From: Richard Castro-Parker
Sent: 22 July 2019 12:08
To: Juan Baeza <Juan.Baeza@arun.gov.uk>
Subject: FW: Windroos, Littlehampton

See below re drainage engineer comments re: LU/24/19/DOC. As the Council's drainage comments have been summarised by the Agent, I have spoken to Laura Gibbons directly this morning. Laura will forward me a copy of her comments directly. Once I have these I will get them uploaded and let you know.

I am happy with the proposals now. Therefore, I recommend discharge of condition 9. I believe that the most up to date drawings and calculations are as contained within the folder here: [REDACTED]
[REDACTED]

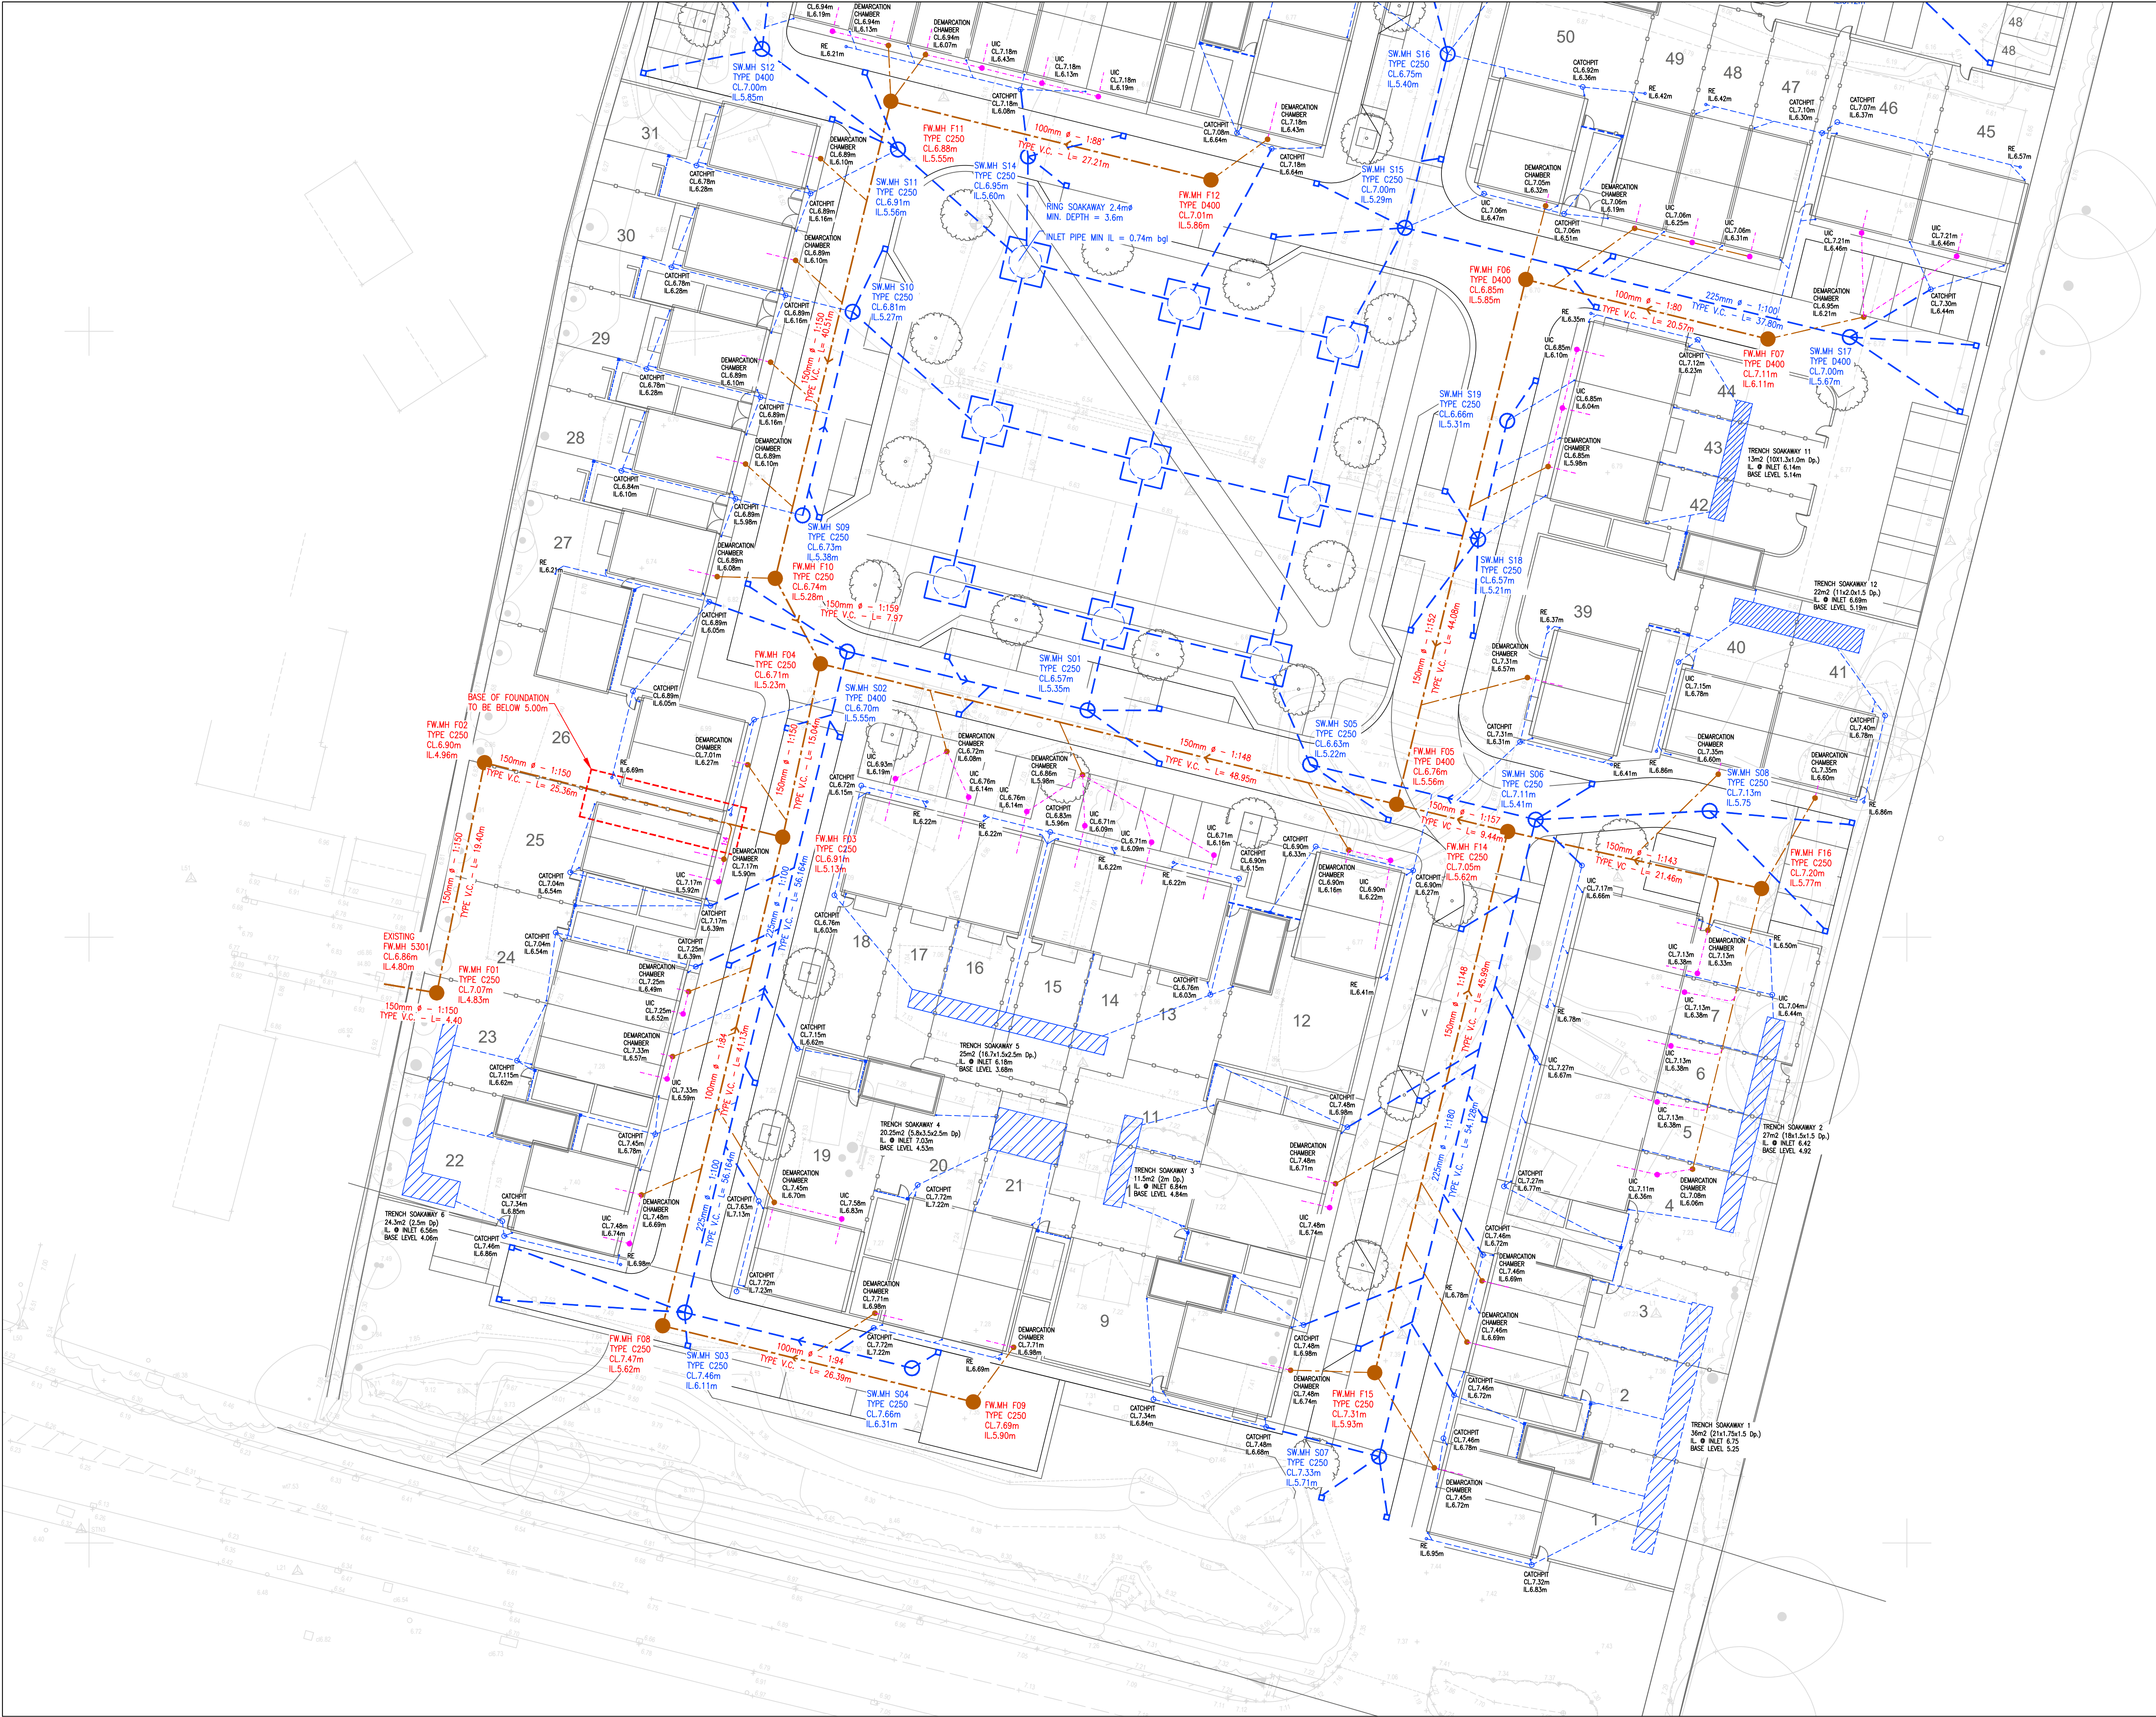
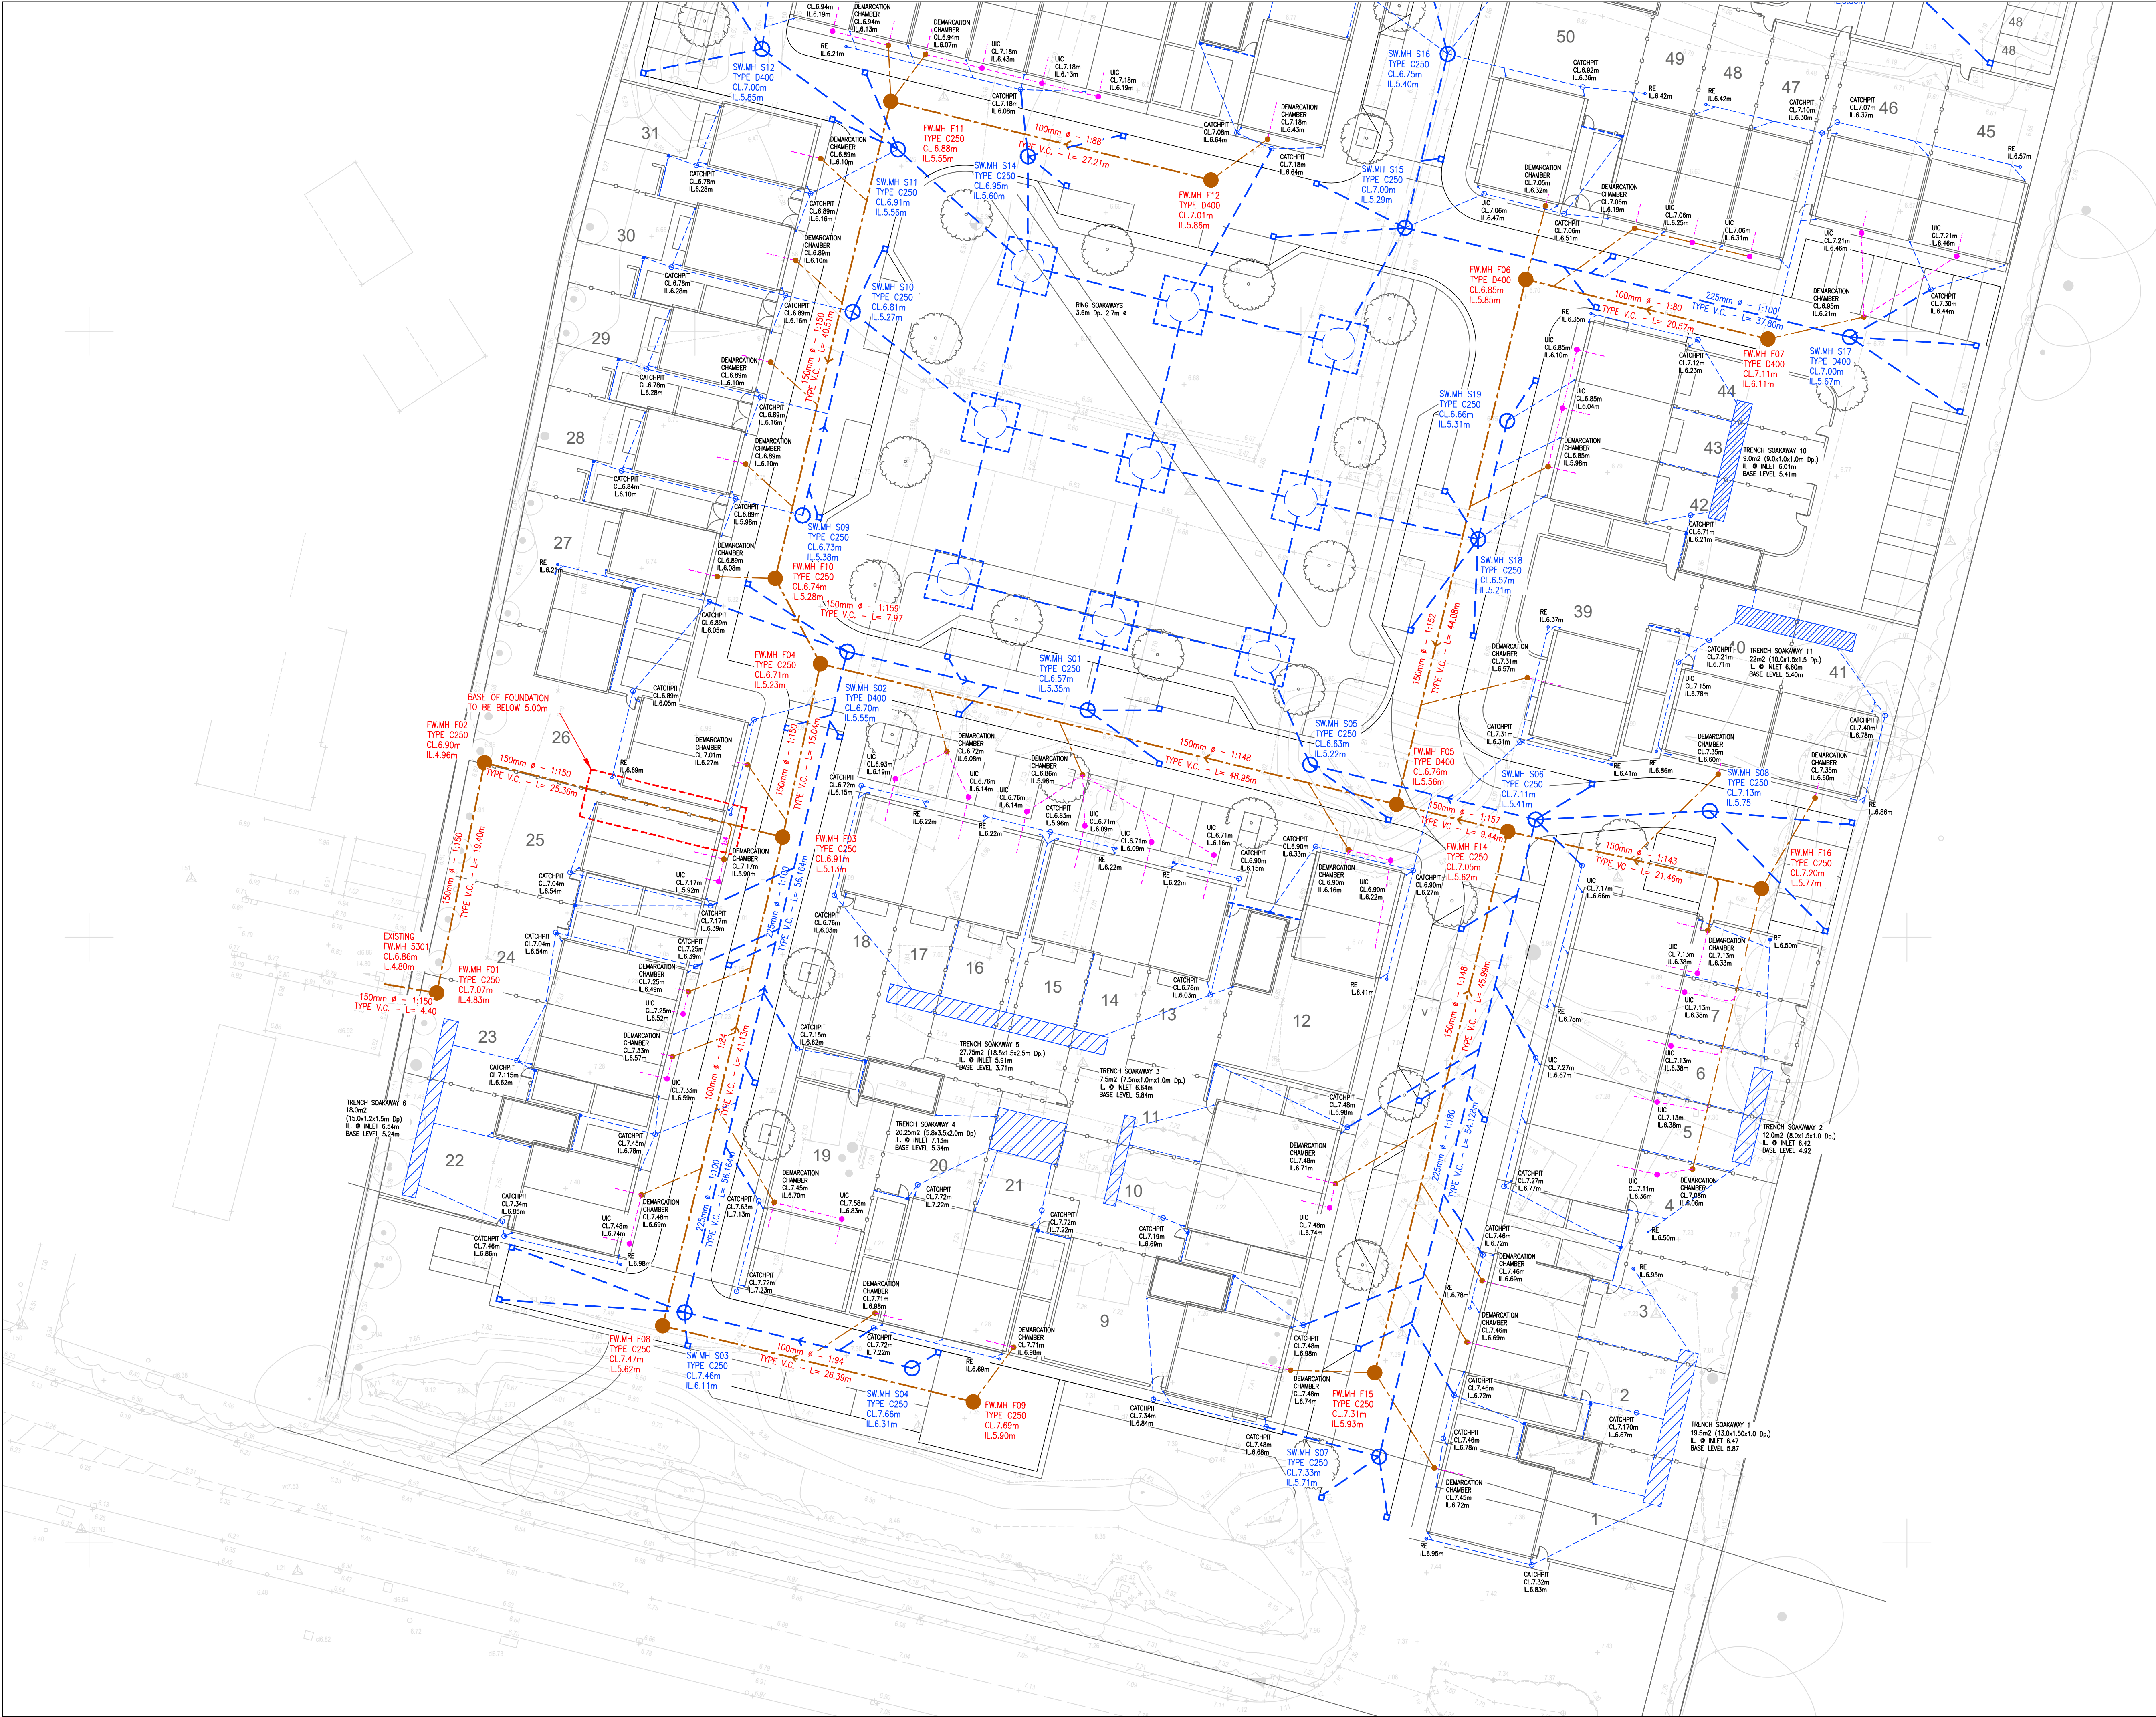
1. There are inconsistencies between the modelled depths and depths shown on plan of soakaways. Furthermore, some of the soakaways have depths greater than the difference between the cover (nearby levels, levels not given at soakaway) and invert levels specified. Please ensure that minimum cover requirements are met and that details are consistent.

3. The calculation for 5 ring soakaways use a diameter of 3m. Yet 2.7m diameter is specified on plan. Again calculations and details need to be consistent.

4. Updated calculations for the 9 ring soakaways have not been provided and need to be.
5. Catchpits are not shown upstream of all connections into soakaways. These must be provided.

6. Cover levels at soakaways are not provided. These must be detailed.
7. Catchpits need to be labelled with sump depths.
8. Ring soakaway drawings need updating to show step irons, clean granular surround, geotextile, hole in base, etc. Please see attached document for an example.

1. There are inconsistencies between the modelled depths and depths shown on plan of soakaways. Furthermore, some of the soakaways have depths greater than the difference between the cover (nearby levels, levels not given at soakaway) and invert levels specified. Please ensure that minimum cover requirements are met and that details are consistent. Cover levels have been added to soakaway structures and minimum cover levels have been ensured.

3. The calculation for 5 ring soakaways use a diameter of 3m. Yet 2.7m diameter is specified on plan. Again calculations and details need to be consistent.
The 5 no. ring soakaways have a diameter of 3.0m which is now reflected in both the plans and on the calculations.

4. Updated calculations for the 9 ring soakaways have not been provided and need to be. These are provided as attached.
5. Catchpits are not shown upstream of all connections into soakaways. These must be provided.
Catchpits have been included upstream of all soakaways.

6. Cover levels at soakaways are not provided. These must be detailed.
These are now included in the plans.
7. Catchpits need to be labelled with sump depths.
Sump depths included in the plans.

PIPE BEDDING DETAIL

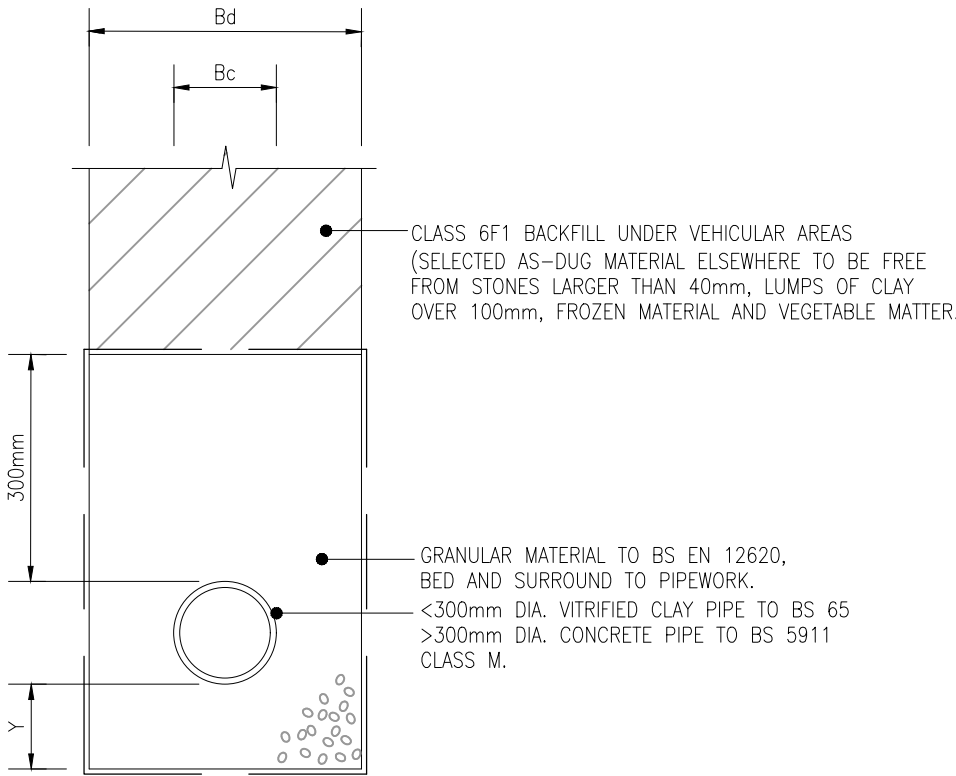
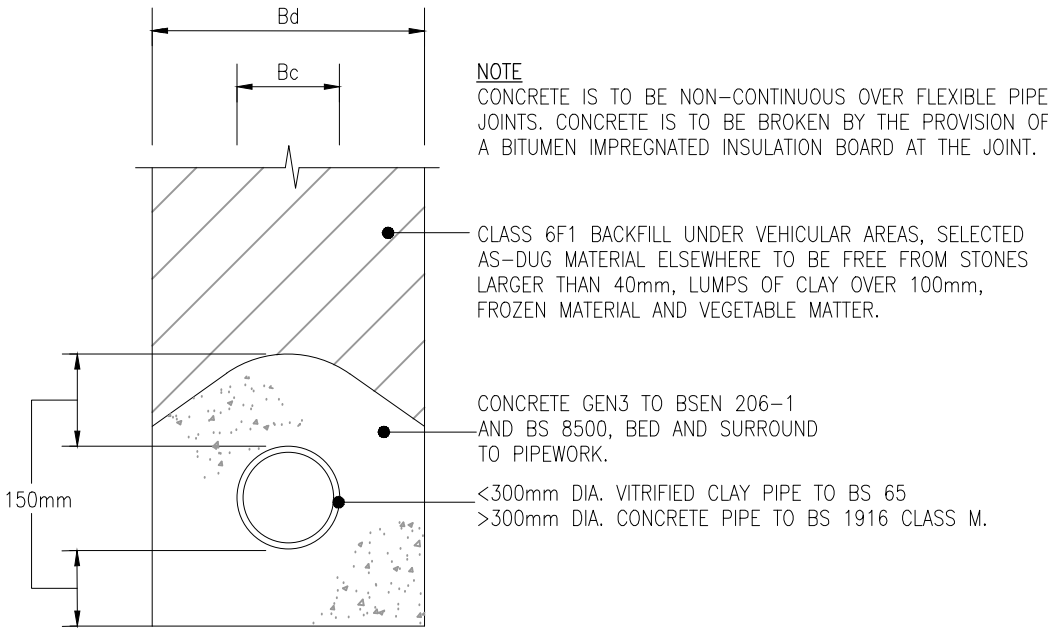
9. Construction detail drawings need to be provided of pipe bed and surround, manholes and catchpits.

9. Construction detail drawings need to be provided of pipe bed and surround, manholes and catchpits.
Construction details for these items have been provided as attached.
